Application for a Non-Material Amendment Following a Grant of Planning Permission

Number	
Suffix	
Property Name	Granite House
Address Line 1	Chapelgate
Address Line 2	Gedney
Address Line 3	Lincolnshire
Town/city	Spalding
Postcode	PE12 0BJ

Increase the height of the first floor bedroom windows, W01, W02, W03, W04, W09 and W011 from 900mm to 1200mm.

CJQ-079-P01 Rev B

Proposed East Elevation
Scale 1:100

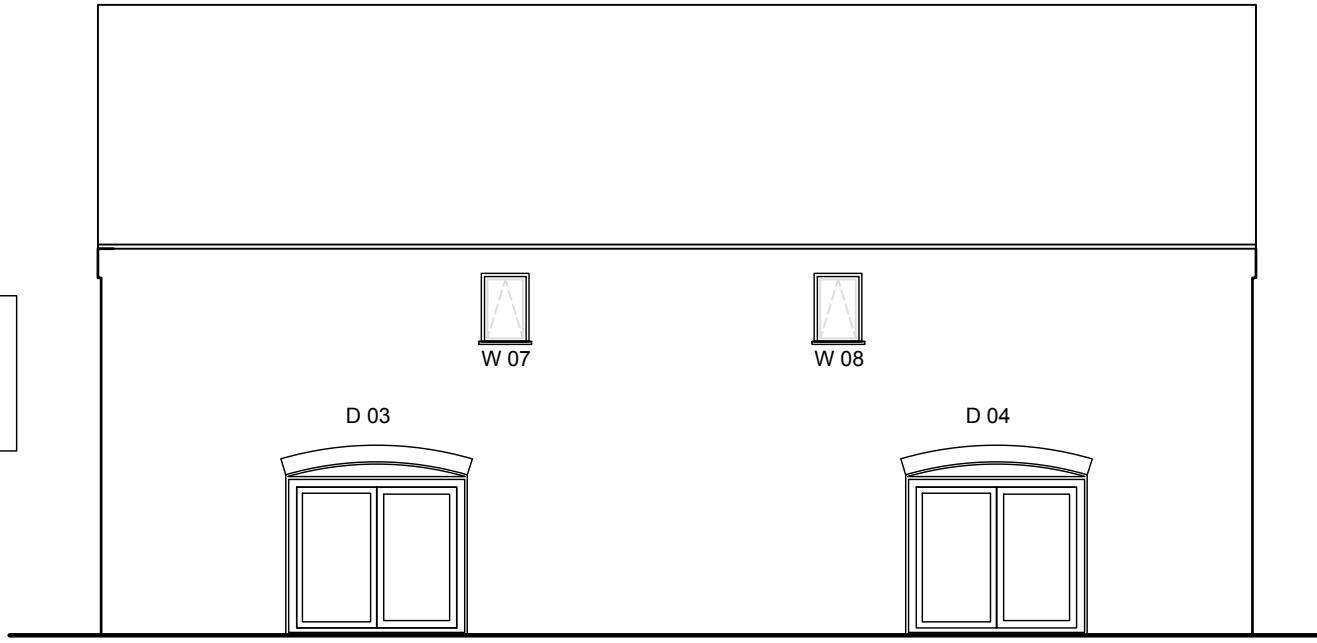
Windows W01, W02, W03, W04 are located on the East elevation.

Alteration of the upstairs windows to 1200mm are in height only. The position of the top of each window is to remain as per the original drawing and the alteration to the windows height will change the position of the bottom of each window, thus reducing the height to the floor to allow for compliance to Escape Regulations.

The size of the upstairs bedroom windows will be changed from 900mm width x 900mm height, to 900mm width x 1200mm height.

The alteration in height will provide emergency egress to first floor habitable rooms.

This allows for the bottom of the openable area to be not more than 1100mm above the floor.

Barn Proposed South Elevation
Scale 1:100

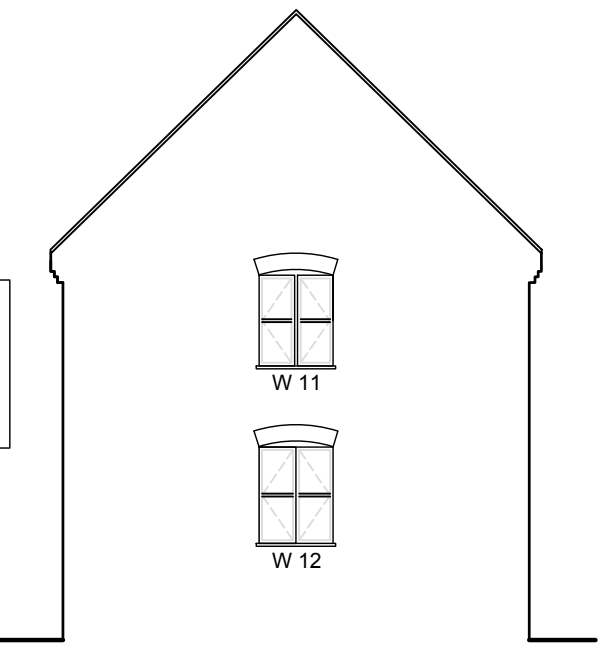
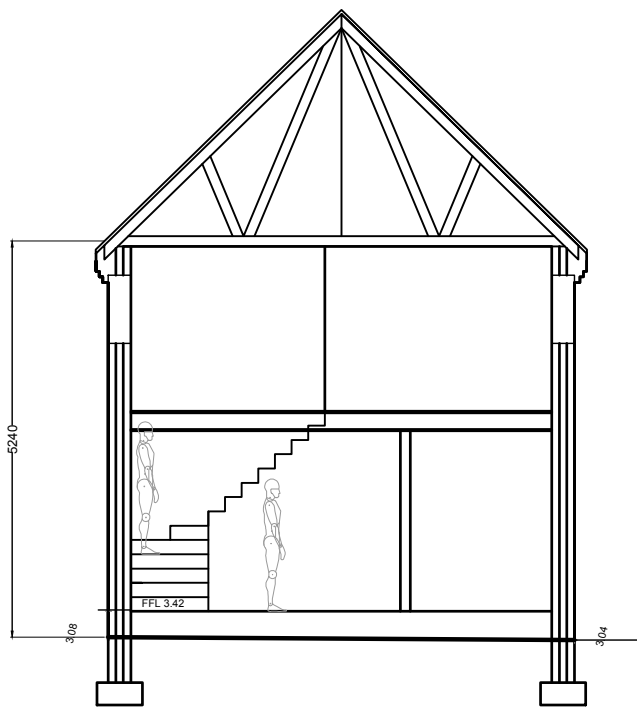
Windows W09 is located on the South elevation and Window W011 is located on the North elevation.
